KIRKLEES METROPOLITAN COUNCIL INVESTMENT & REGENERATION SERVICE

DELEGATED DECISION TO DETERMINE PLANNING APPLICATIONS

Reference No:	2024/62/91826/W
Site Address:	31, The Courtyard, Fenay Bridge, Huddersfield, HD8 0FT
Description:	Erection of single storey rear extension
Recommending Officer:	Joanna Rednall

HOUSEHOLDER DELEGATED REPORT

Proposed layout (1:100)

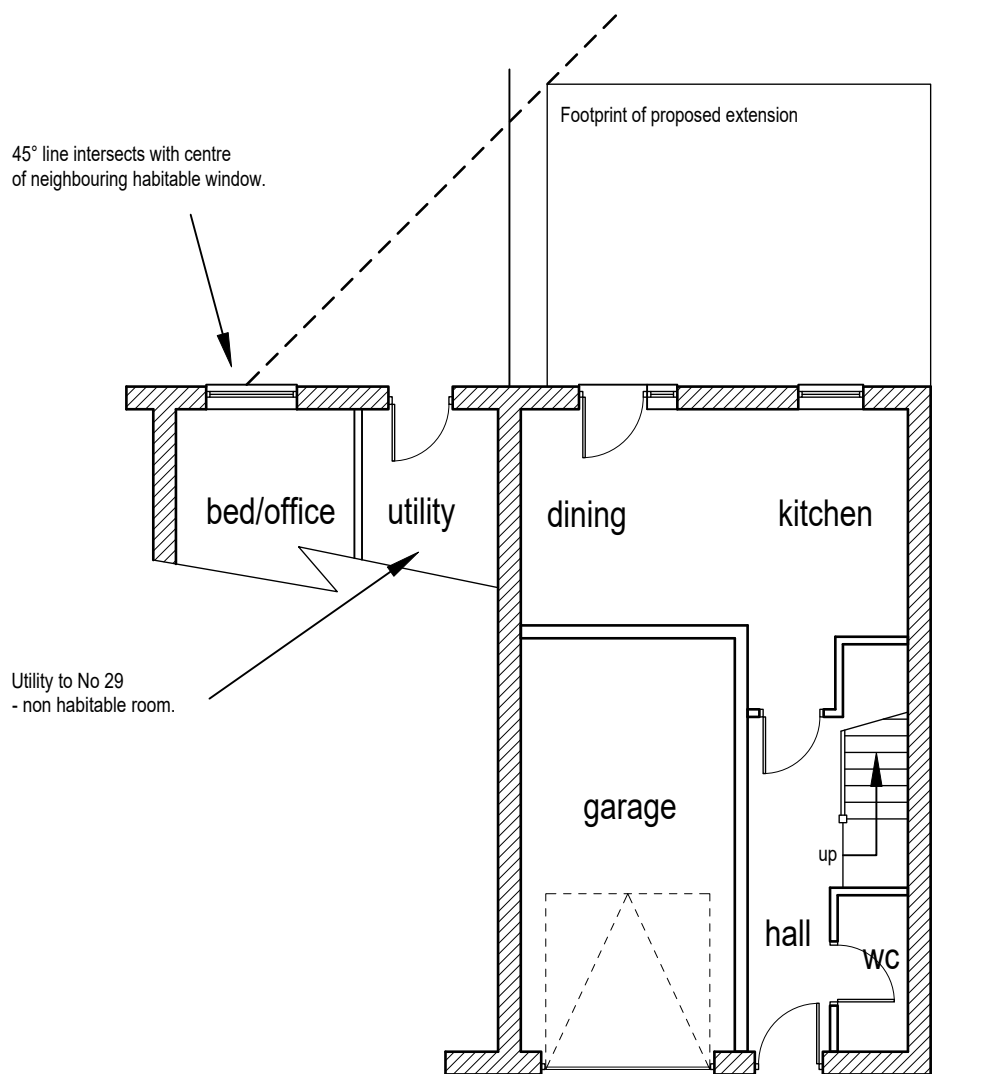
In regard to overshadowing, further information has been submitted by the applicant's agent to show a 45 degree line from the midpoint in the closest habitable window of No.29 from the proposed extension. The 45 degree line would not be significantly cut, and therefore any overshadowing impact is not considered to be significant in this case. Alongside this, the submitted plans show no additional openings to be inserted into the north facing side elevation which will mitigate any undue harm on overlooking.

Proposed ground floor layout (1:50)

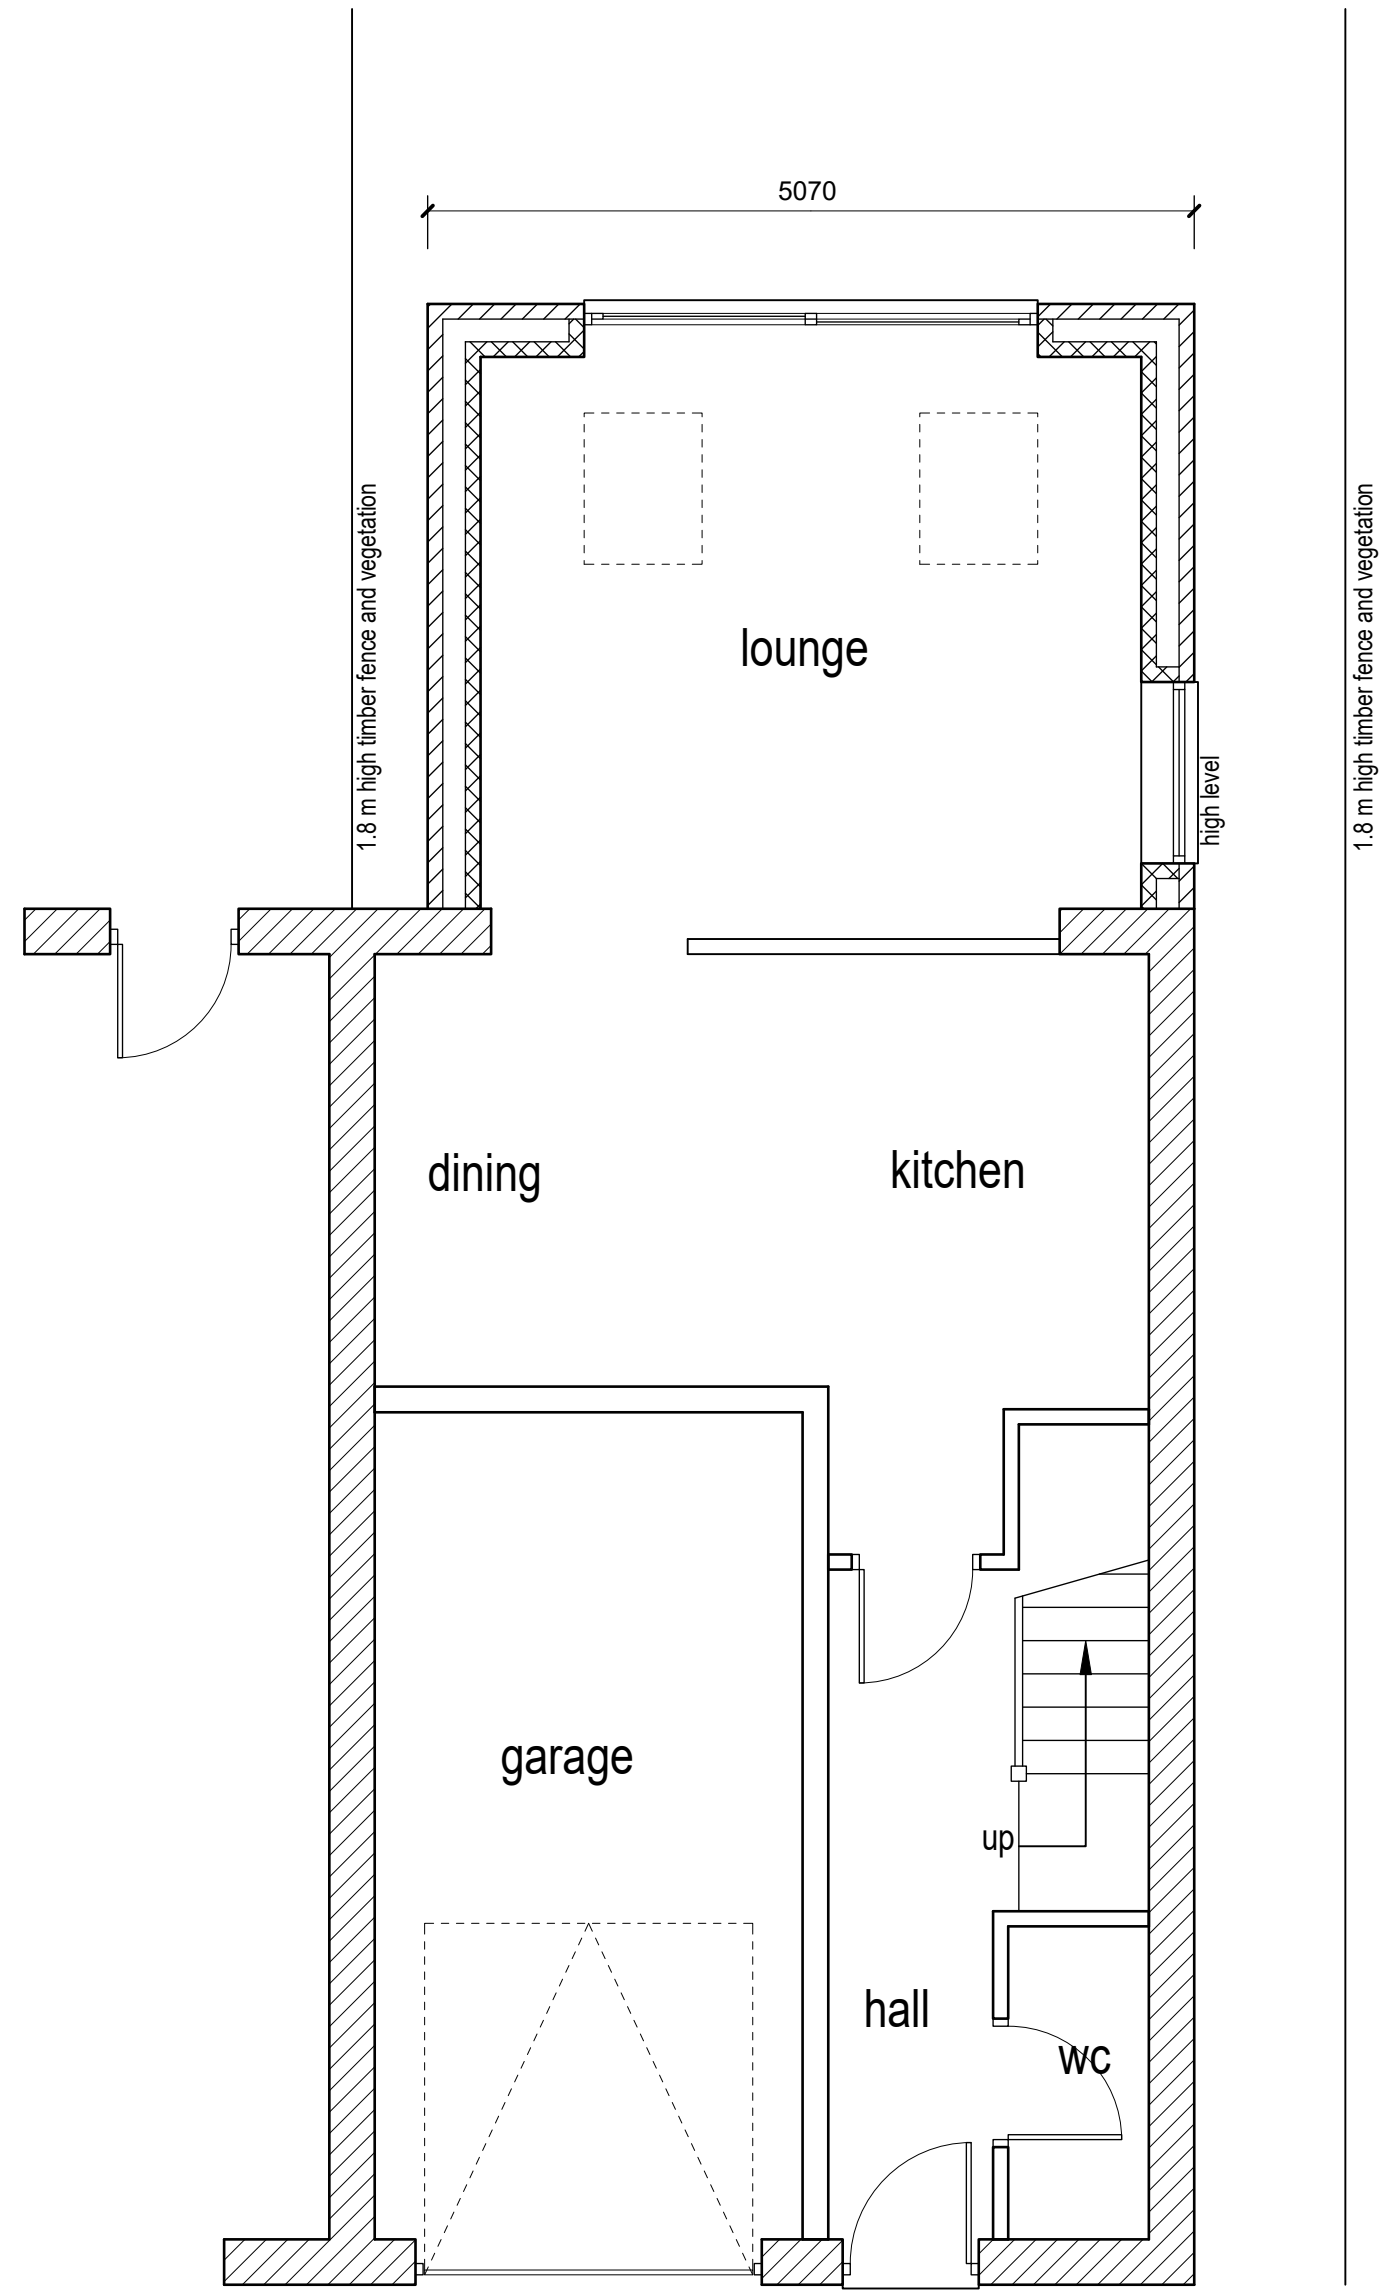
retain a gap of at least 1 metre from a property boundary, such as a wall, fence or hedge	<u>The extension would only retain a ~0.5m gap from north-facing boundary.</u>	The submitted plans indicate boundary treatment in the form of 1.8m high timber fence and vegetation that would screen the majority of the development. Although the extension is not set 1 metre away from the boundary, it is considered there would be no design benefit in setting the extension in by a whole meter and it would be unreasonable of the LPA to request such an amendment in this case.
---	---	---

The extension is set off the shared boundary by ~0.5m. While the extension would intensify development close to the shared boundary, the submitted plans indicate boundary treatment in the form of a 1.8m high fence which would alleviate some of the bulking/massing neighbouring this dwelling.

Proposed side/south facing elevation (1:100)

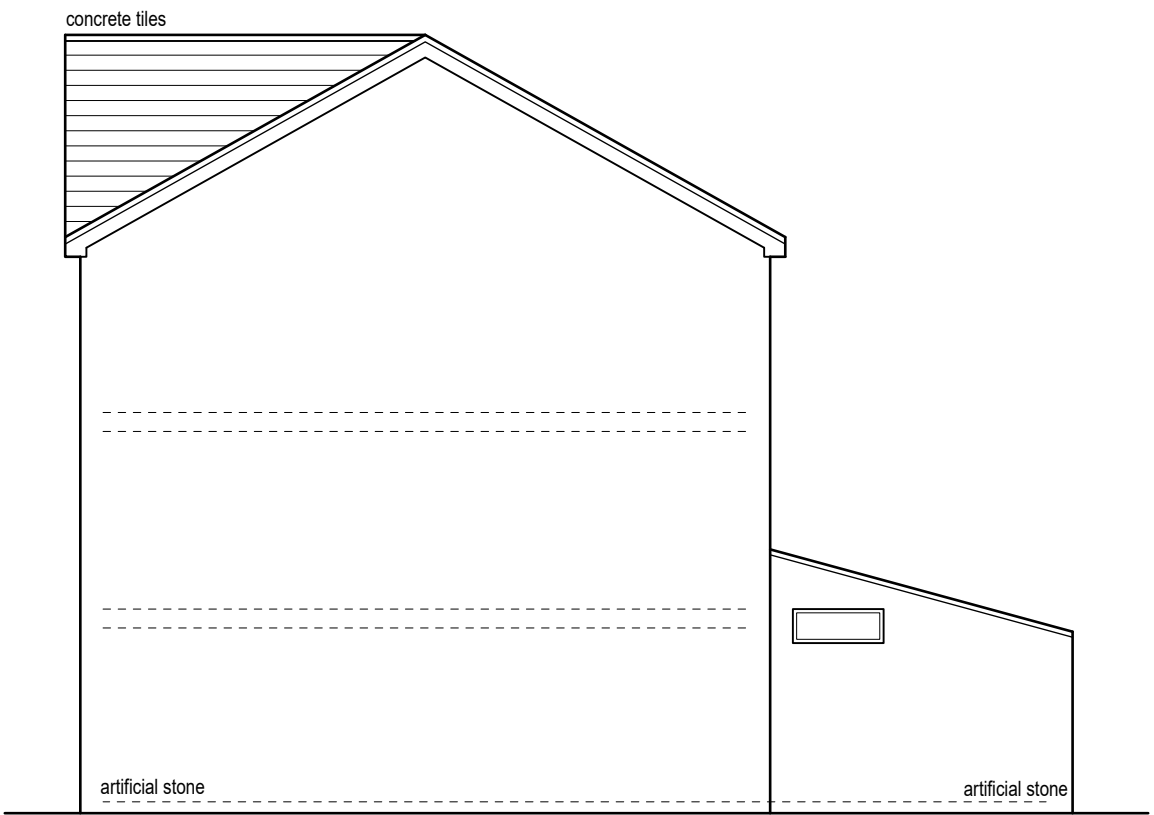
With regard to overlooking, one new window will be inserted into the side/south facing elevation of the extension. However given that this is a high window and existing boundary treatment, which will be retained as part of this proposal, on balance the level of overlooking possible from this window would not be significant. The high level placement of the window in the wall, and the fact boundary screening is between these properties leads to the conclusion overlooking from this elevation would not be to such a degree as to warrant refusal in this case.
